**DELEGATED DECISION TO DETERMINE APPLICATIONS FOR
NON-MATERIAL AMENDMENTS**

Reference No: 2021/NM/91567/W

Site Address: 1, Rose Mount, Birkby, Huddersfield, HD2 2BU

Description: Non material amendment to previous permission
2020/90417 for erection of single storey extension

North Elevation_proposed

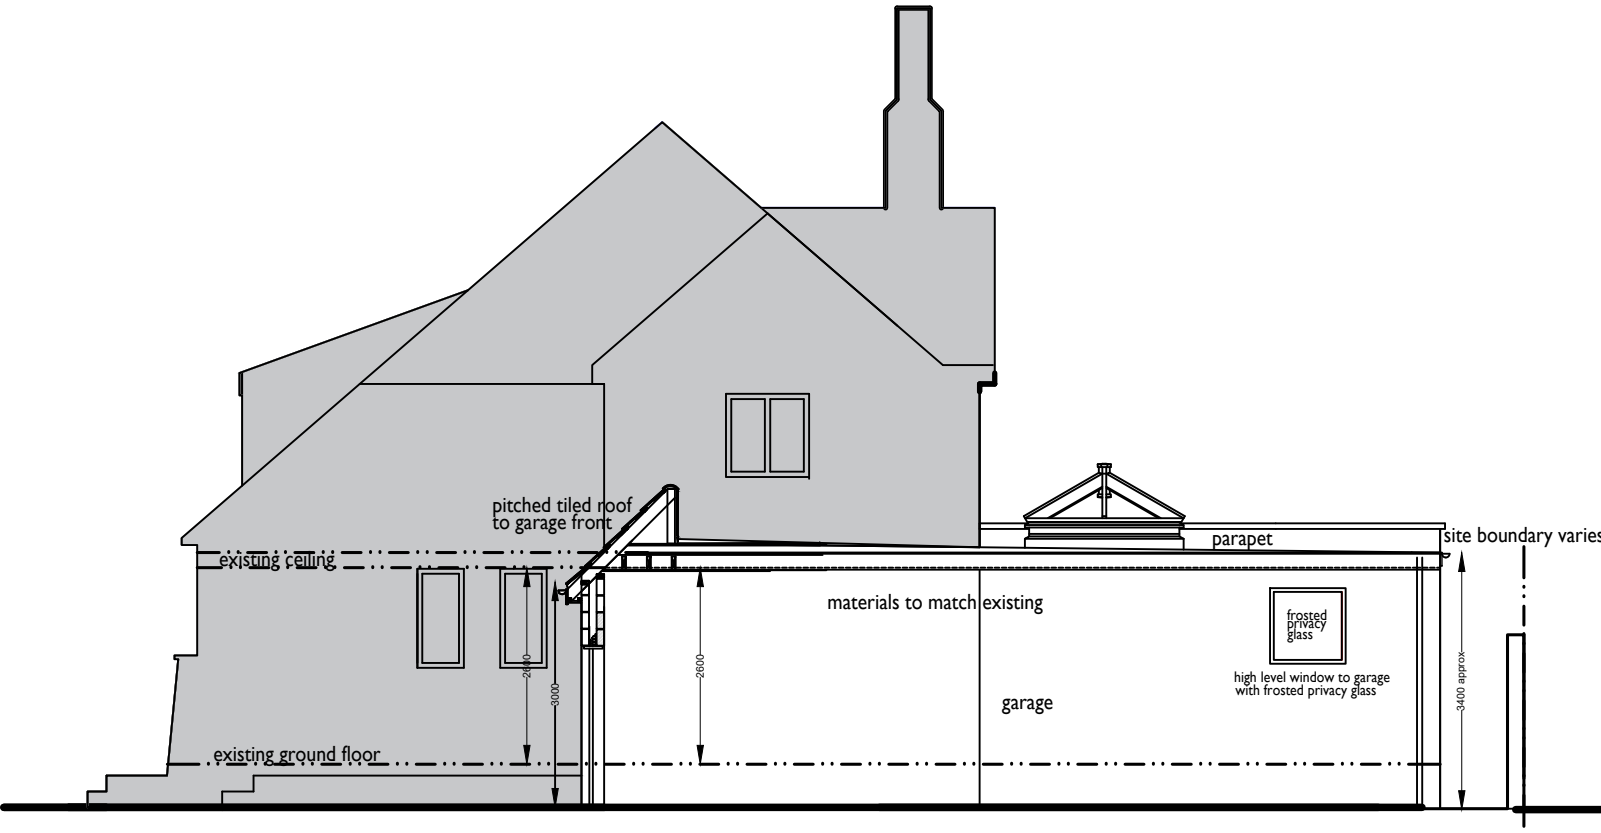
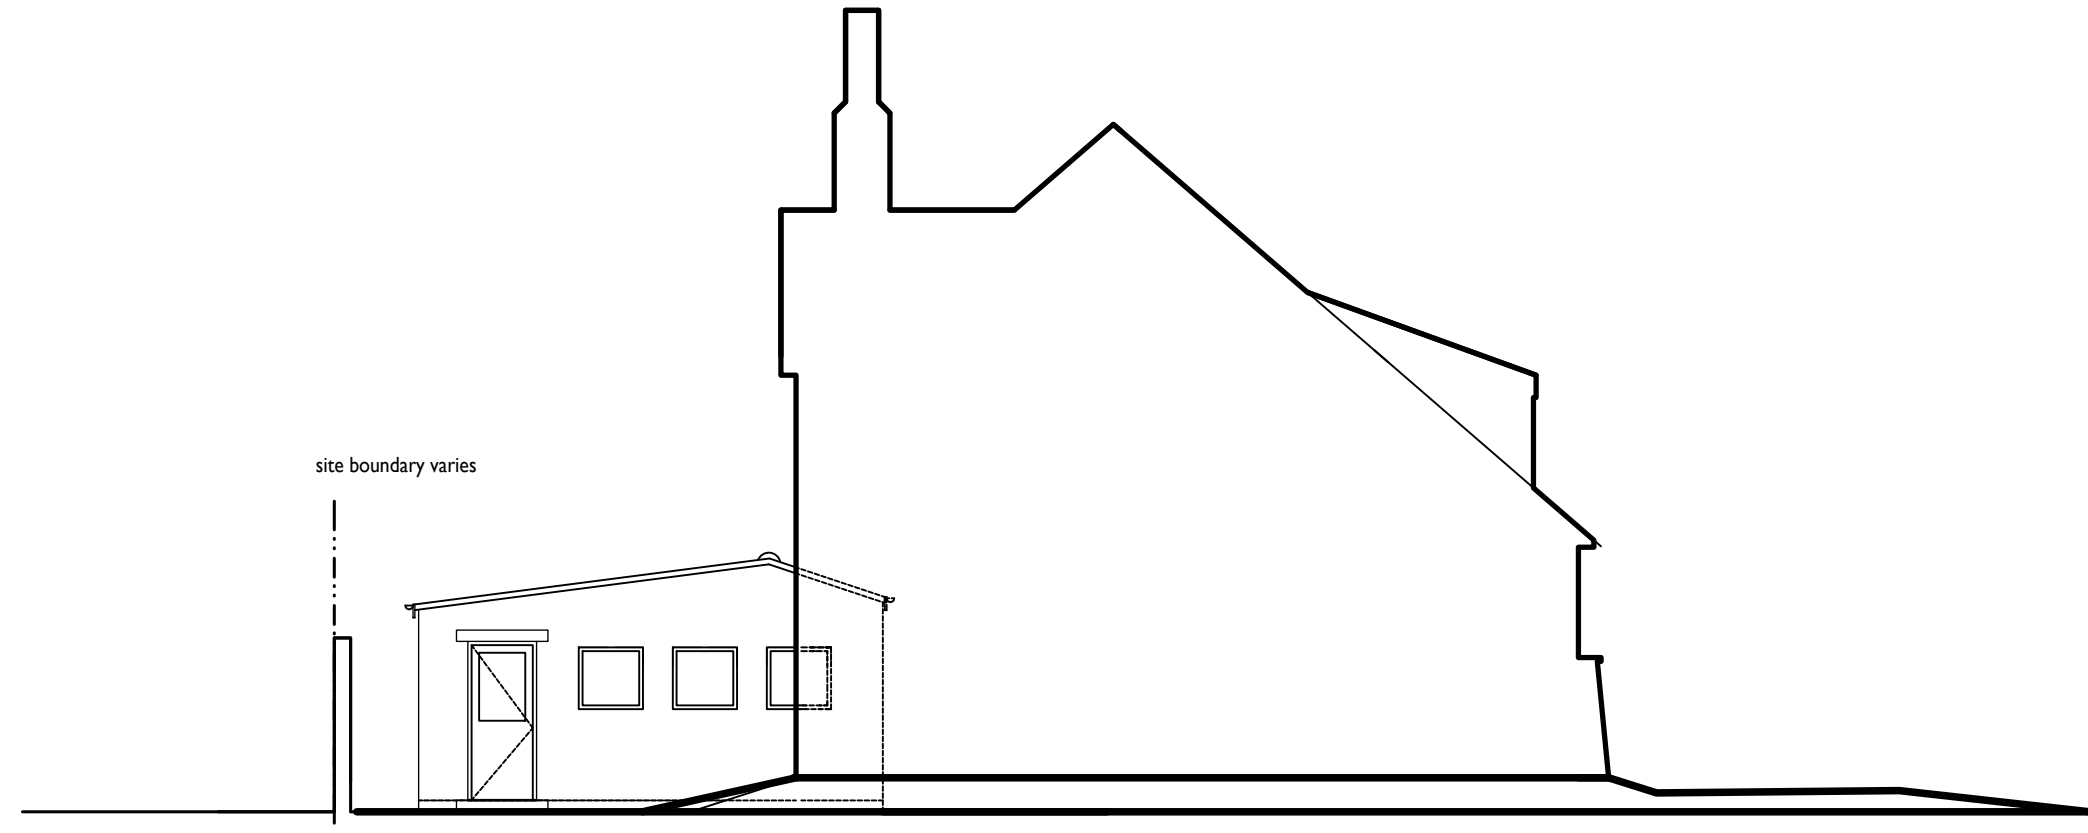
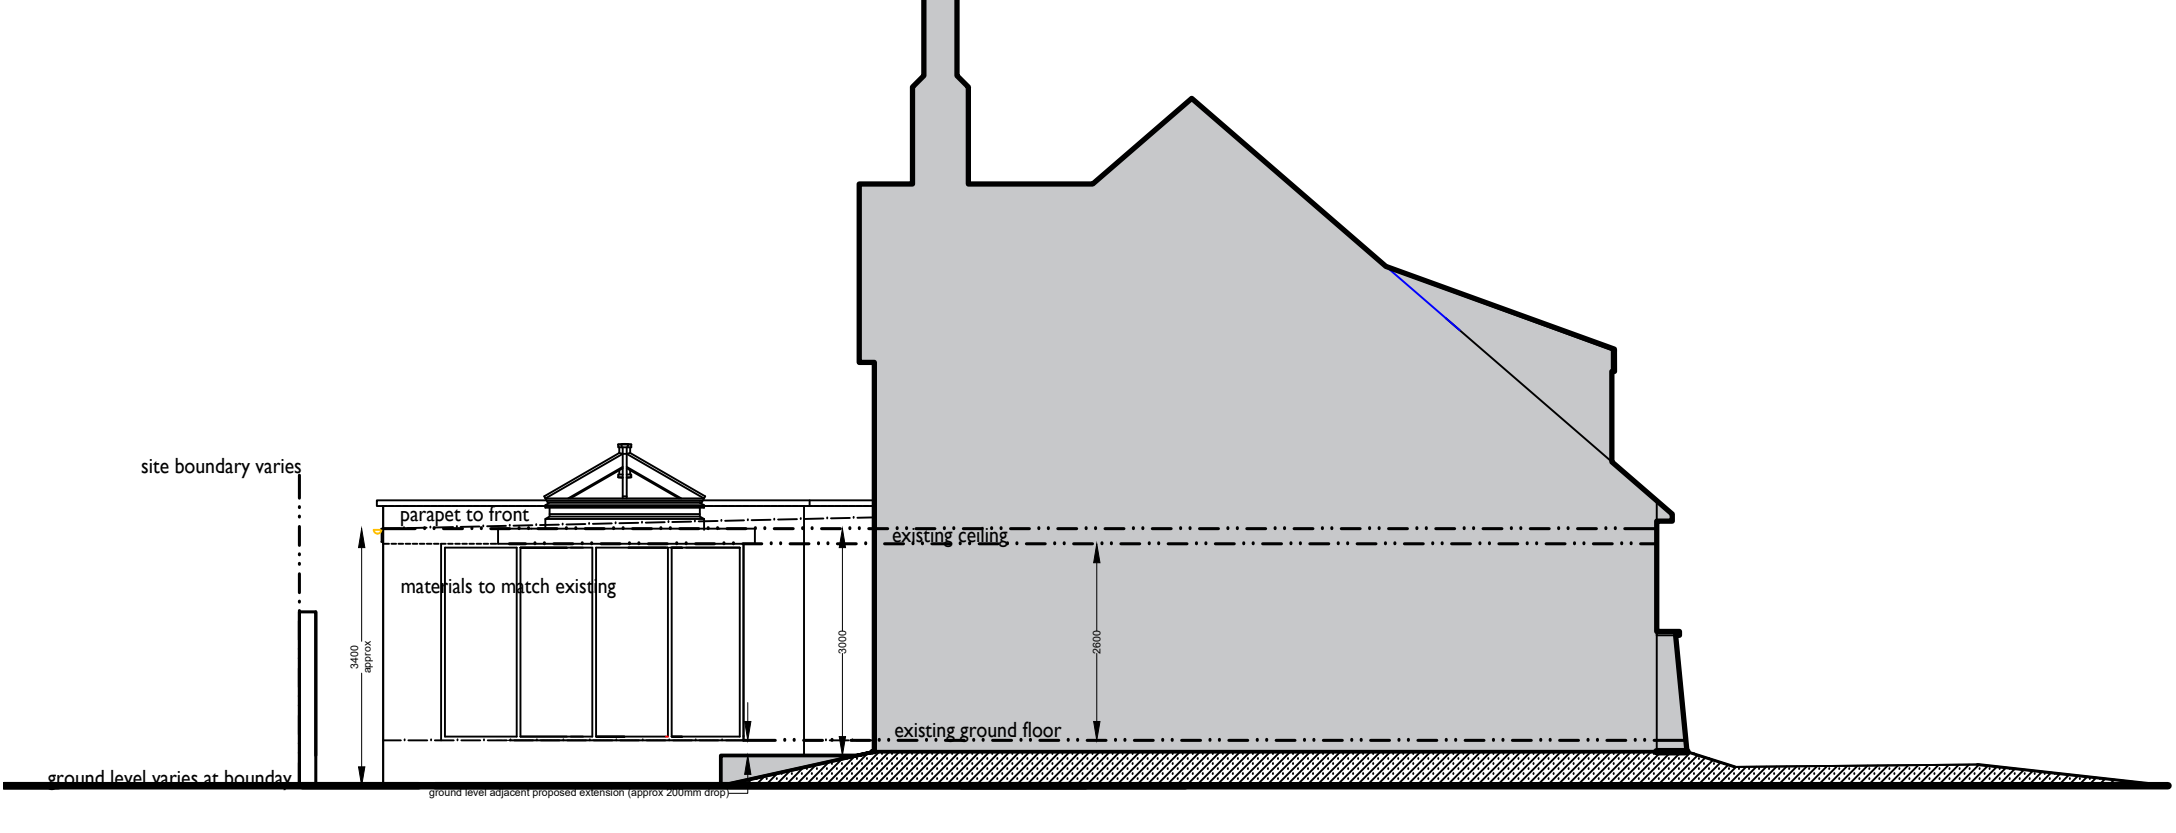
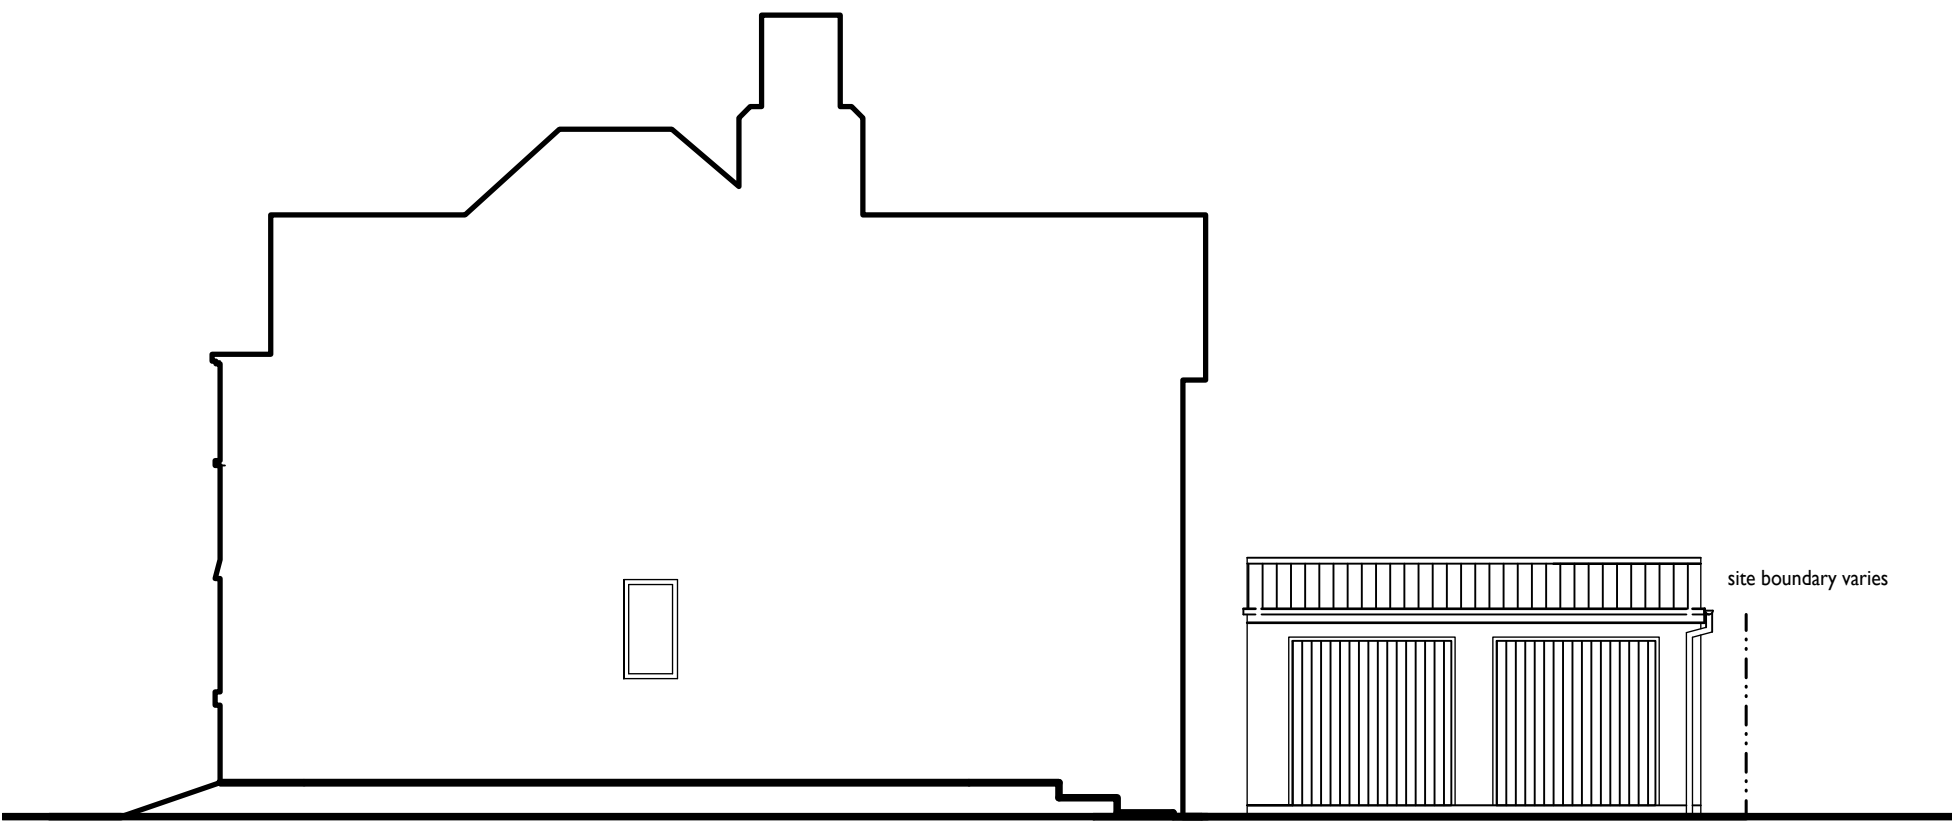
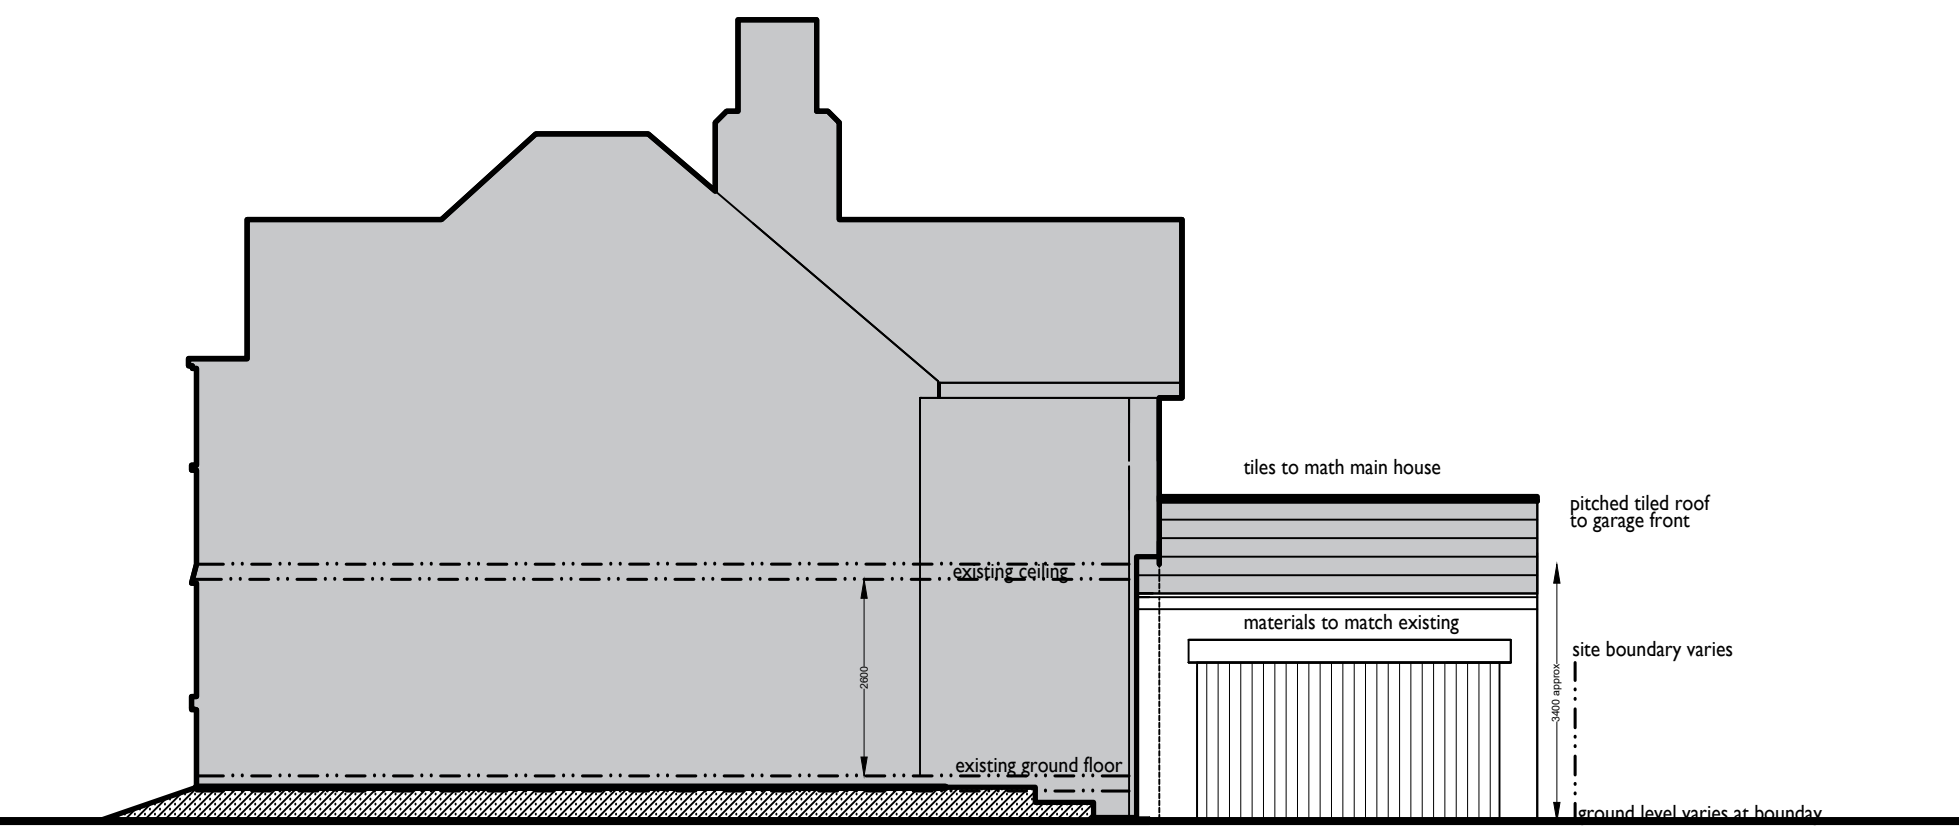
The amendment relates specifically to a longer roof lantern within the kitchen, a small set back to the rear wall of the garage and also a small pitch to the front of the garage roof.

- The proposed change must not contravene any condition attached to the original permission – **no condition would be contravened. It is noted that additional openings are shown within the side and rear elevations of the garage however there is a condition removing permitted development rights for no new windows or doors. These elements are proposed, and will be considered, in the assessment of 2021/91594**

- The proposed change should not require a further restriction to make it acceptable – **no further restrictions would be required**
- The proposed change would not result in any material increase in height, scale, width or depth of a building - **there is an increase in height to the extension however this is minimal and not considered a material increase due to being to the front section of the garage**

The amendment sought is for a longer roof lantern within the kitchen, a small set back to the rear wall of the garage and also a small pitch to the front of the garage roof as shown on drawing numbers Revision 01 Existing and Proposed Elevations and Revision 01 Existing and proposed Floor Plans.

Note: This permission does not extend to the additional window openings within the side and rear elevations of the garage.
